**Howerton Services, PLLC**  
**License # P-1716**  
3513 Cathedral Bell Road  
Raleigh, NC 27614  
(919) 270-3460

Subject: 115 Ponchartrain Street  
Fuquay Varina, NC 27526  
Plan Revision Letter  
Harnett County Permit #: SFD2302-0011

Based on the request of the Contractor, 2 items on the plans will be revised. My assessment and recommendations are as follows:

**702 SECT. THRU PORCH**  
SCALE : 3/4" = 1'-0"

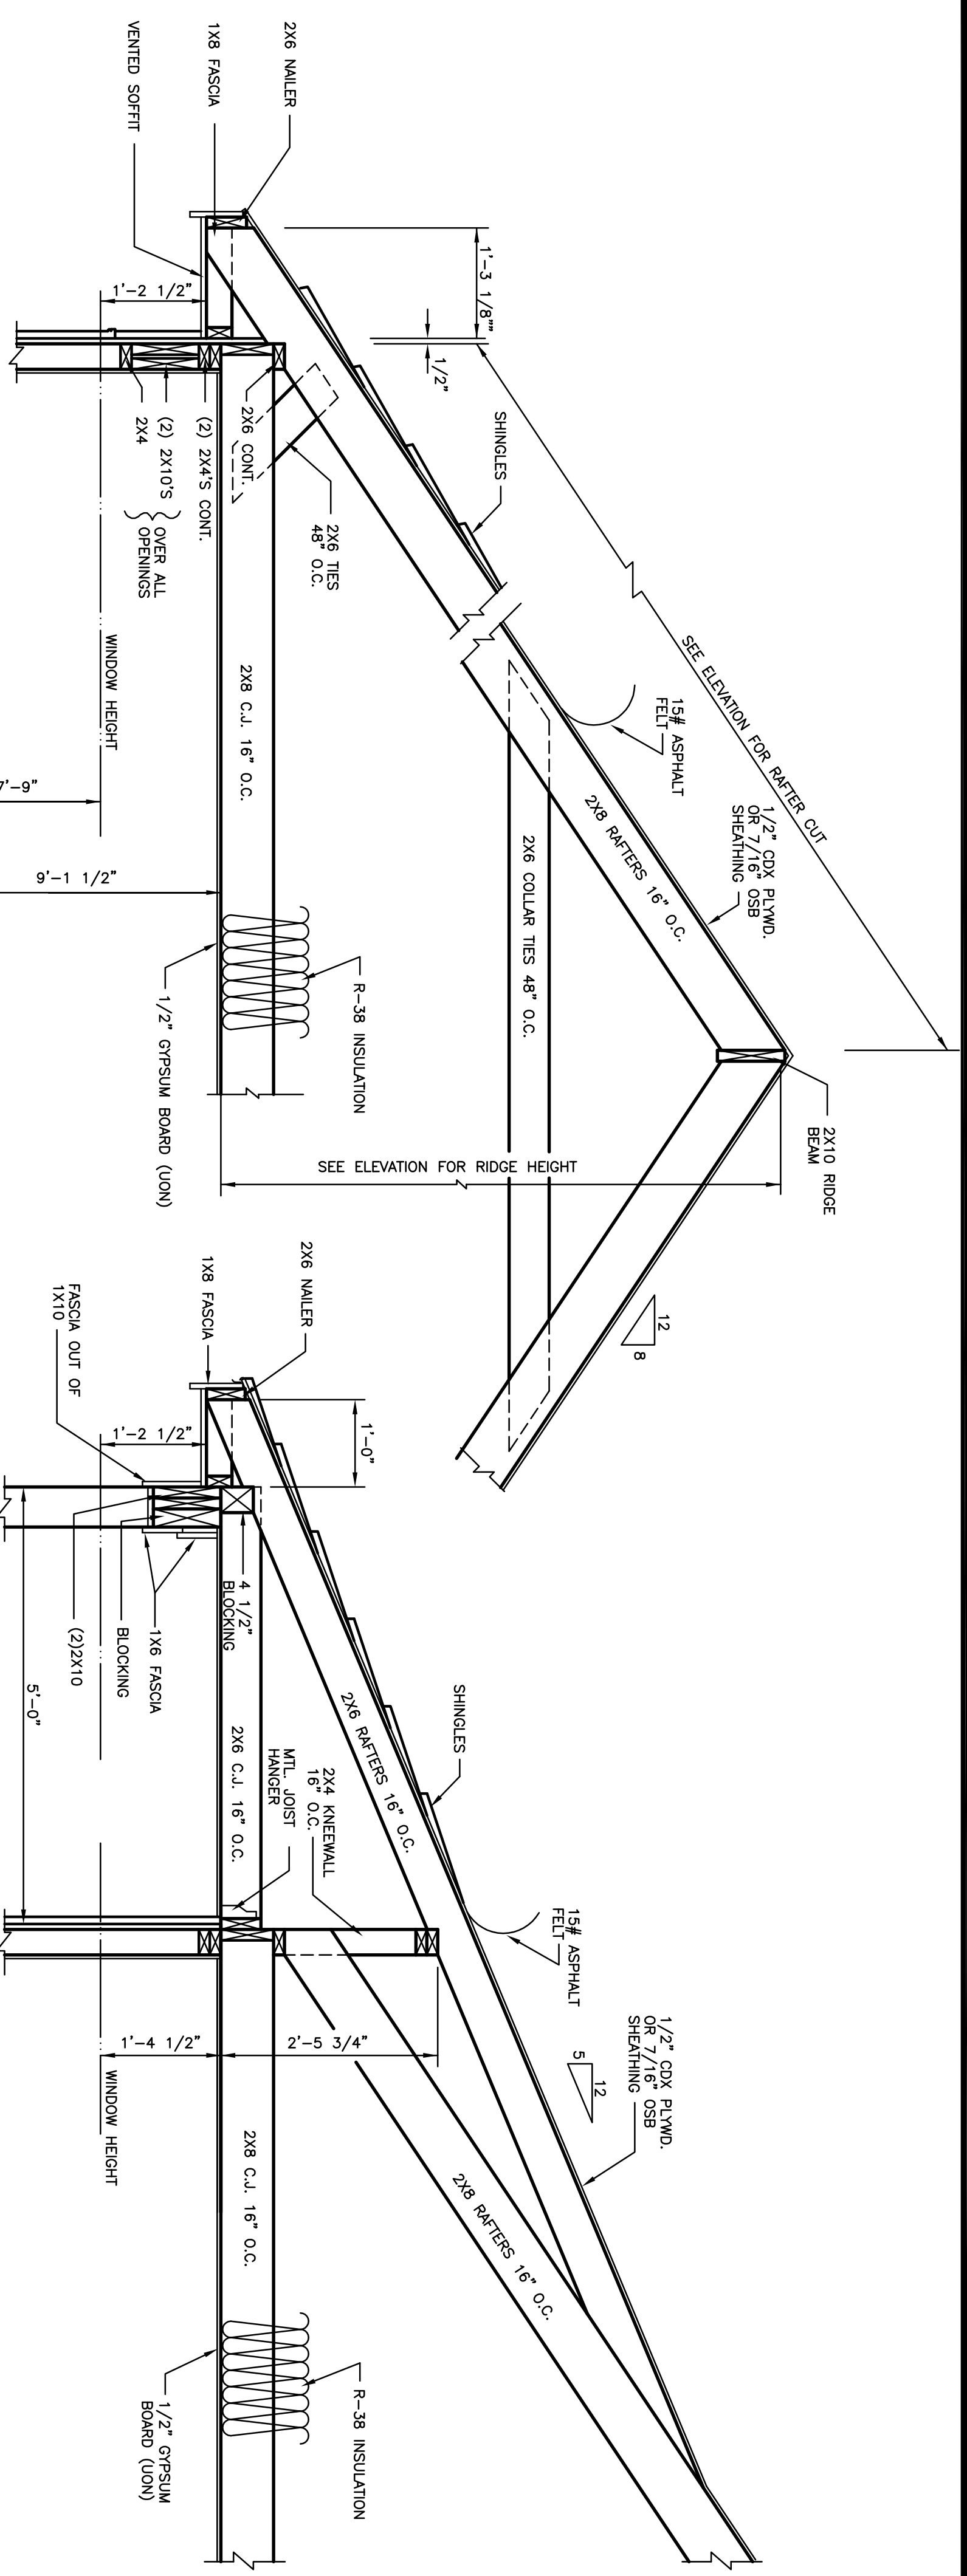
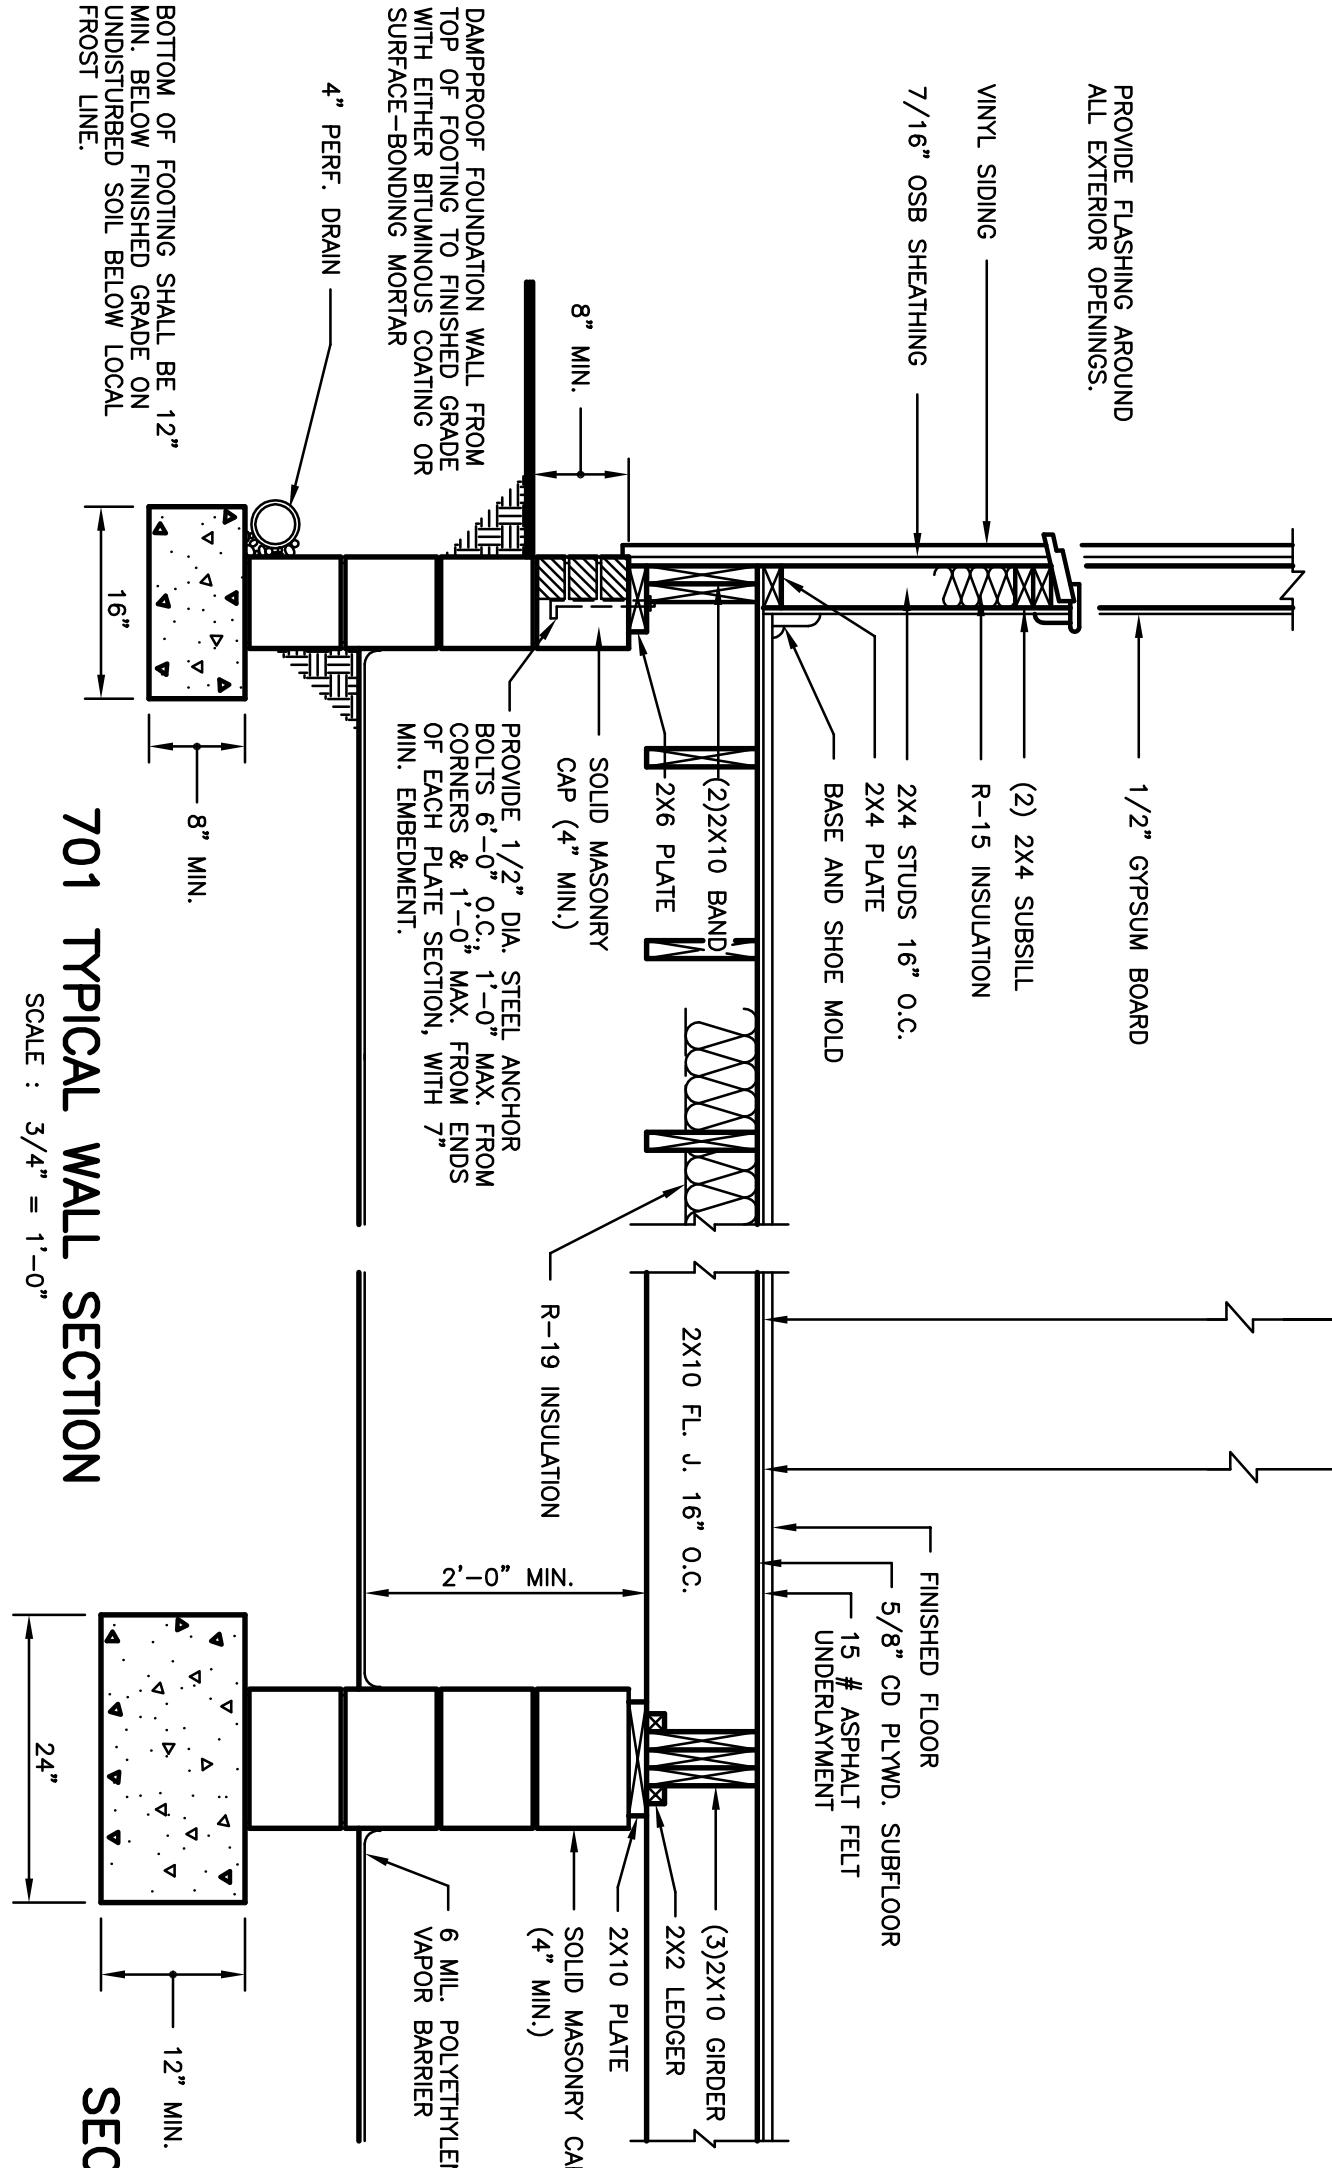
- Item 1 – The double 2x10 front porch beam was changed to a triple 2x10. This beam change is acceptable.
- Item 2 – The double 2x10 beam in the porch ceiling to support the short rafters was changed to a double 2x8. This beam change is acceptable.

The 2 items noted above meet all the requirements of the 2018 North Carolina Building Code for Residences.
